Application for a non-material amendment following a grant of planning permission.

Single storey side and rear extensions and conversion of roof space to habitable use.	
Reference number:	EP/14/21/HH
Date of decision	09/04/2021

Adding two small gable dormers to the south elevation.

Drawing
Proposed Elevations

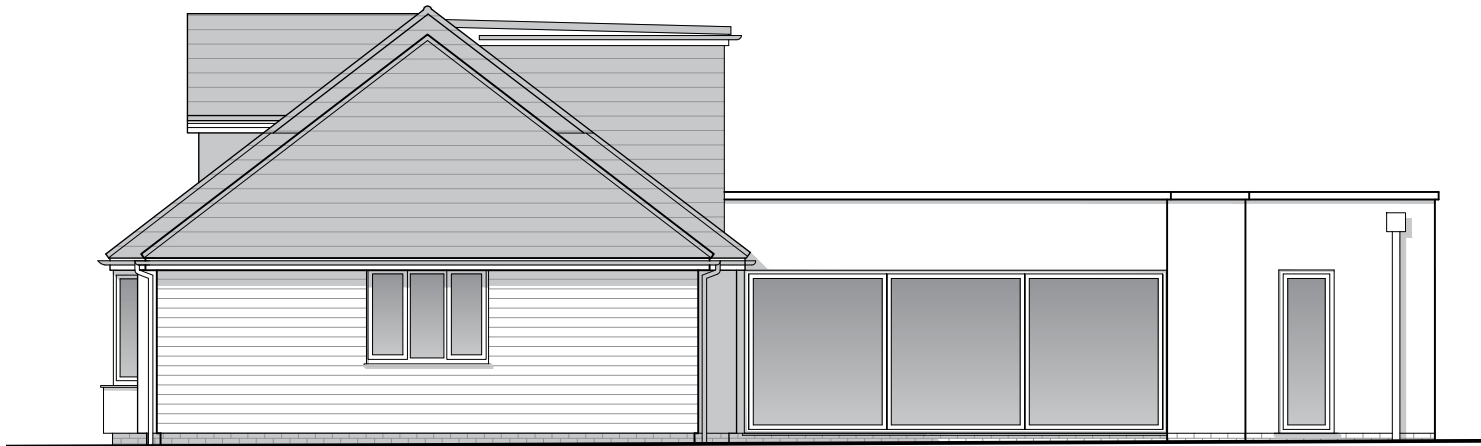
To mitigate overlooking issues raised by the neighbours and WRA. The revised design is also more sympathetic to the surrounding properties which also have gable dormers to the principle elevation.
